RE: Griffith Mercer Island House Deck Remodel
2443 84th Ave SE
Mercer Island, WA 98040
Permit Number: 1906-185
SUB4-PLANS REVIEW RESPONSE

The following are “Jackson Main Architecture” (JMA) responses to the plan review comments raised in the “**SUB-4 Plans Review**” plan review document, sent on **July 9, 2020**. Responses to the review comments are numbered to correspond to the appropriate number in the review comments for the project referenced above.

A2.01

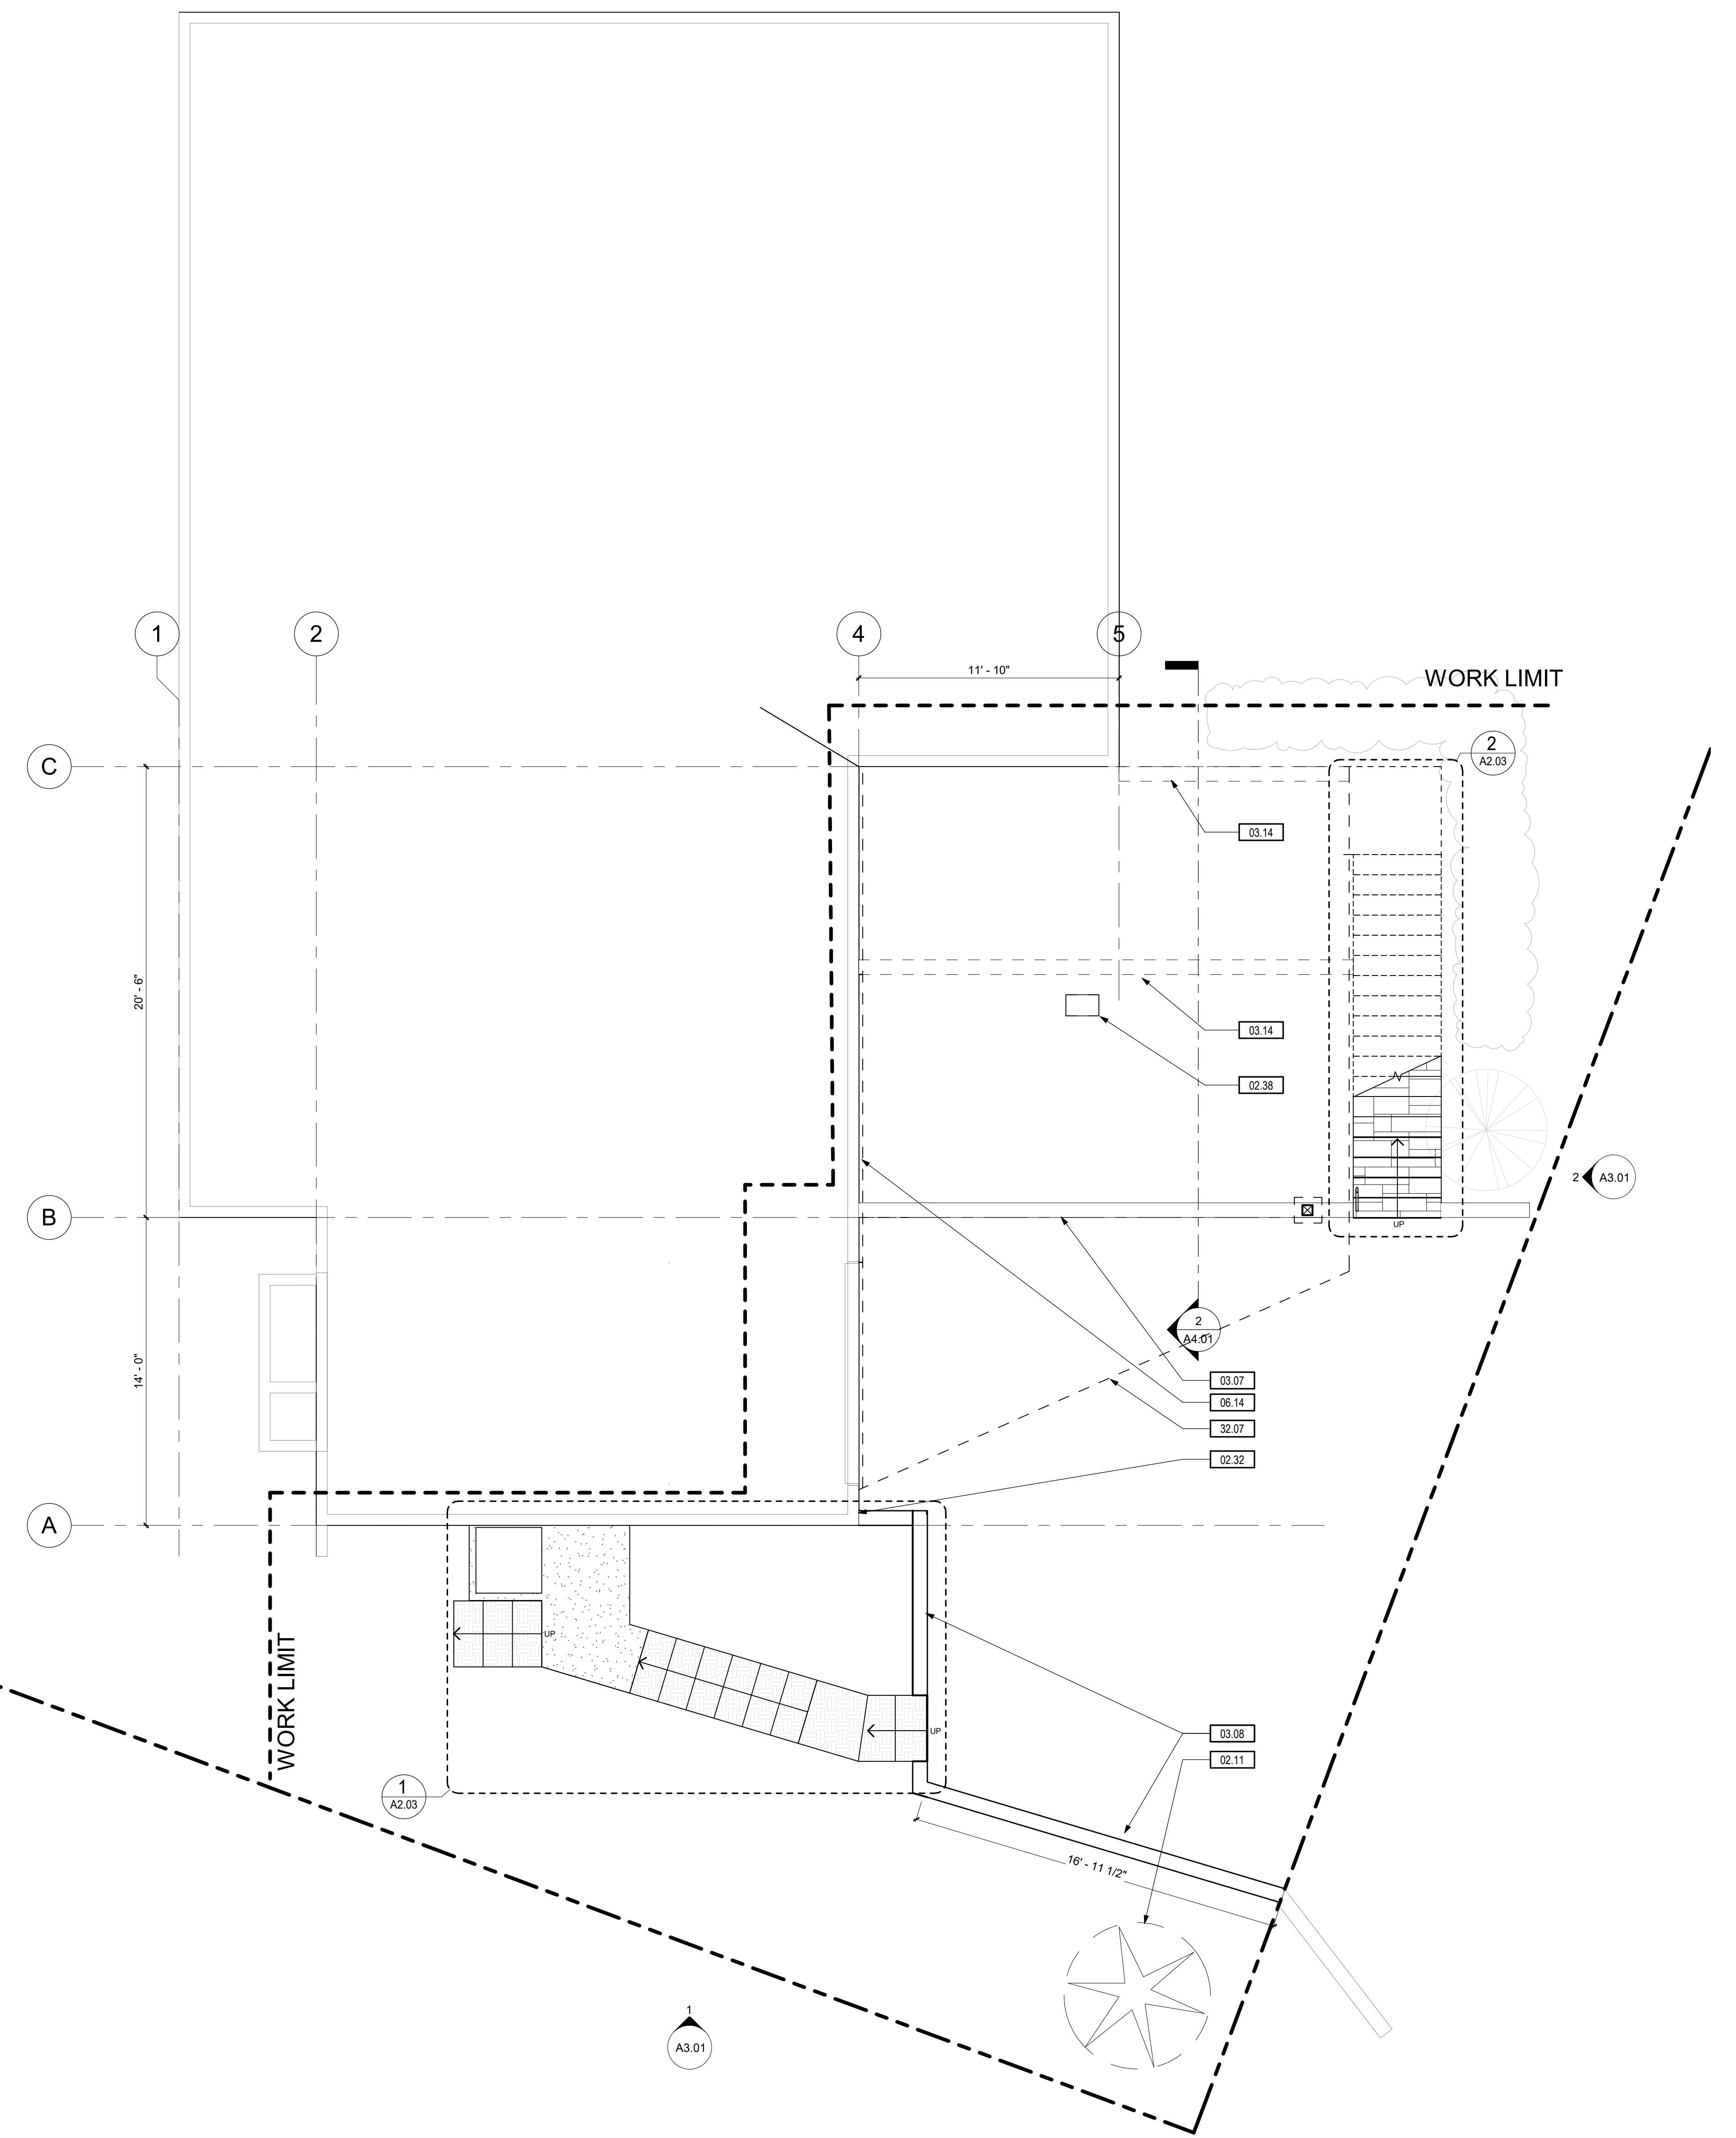
3. *Please also provide a proposed site plan. Please clearly illustrate and label what is existing and proposed on this plan.*

15. *Where is this detail located? Callout all details used on this project. Remove all details not applicable to this project. Coordinate with structural.*

Sheet A0.01 is the Existing Site Plan. Sheet A2.01 shows the new deck and retaining wall. No other work is being done to the site other than these areas.

Bluestone finish is being applied to existing and proposed retaining walls that surround the parking area. These were keynoted on plans and elevations. Please see sheet A2.01 and A 3.01.

ELEVATIONS
A3.01

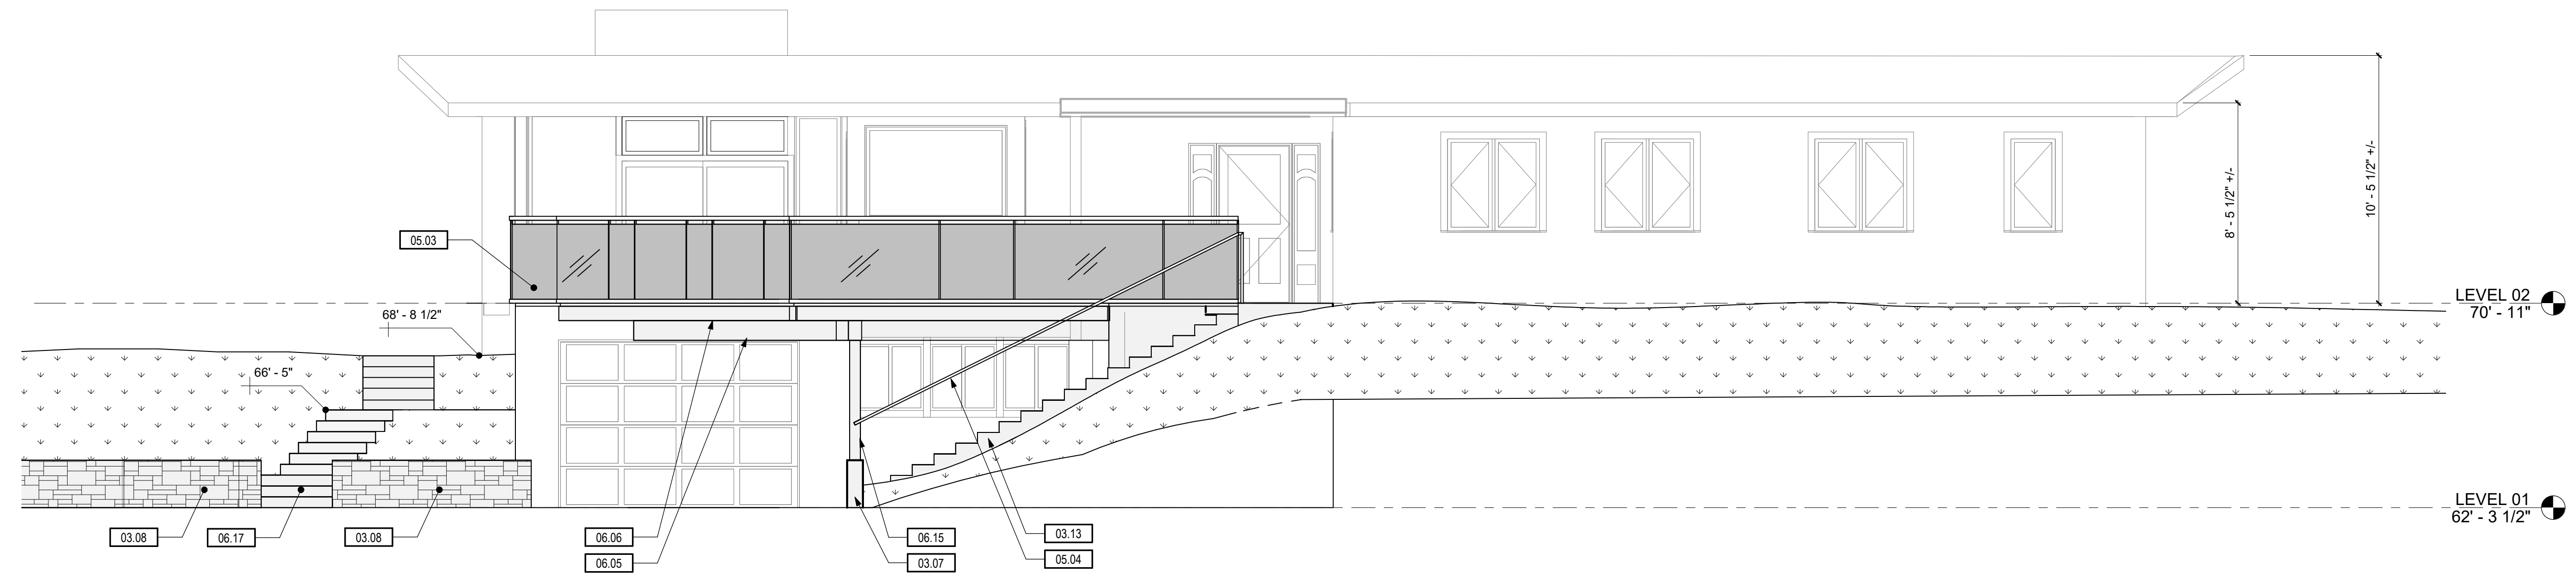
13. *As requested in SUB3, please show and label the existing and finished grade on all elevations.*

14. *Is this a new retaining wall? If so, please provide the height. The height is measured from the existing or finished grade (whichever is lower) to the top of the wall.*

Noted. Please see sheet A3.01.

The stair does not retain soil to the west. A new retaining wall to replace existing is now shown in plans and elevation. Details of this retaining wall are shown in structural drawings.
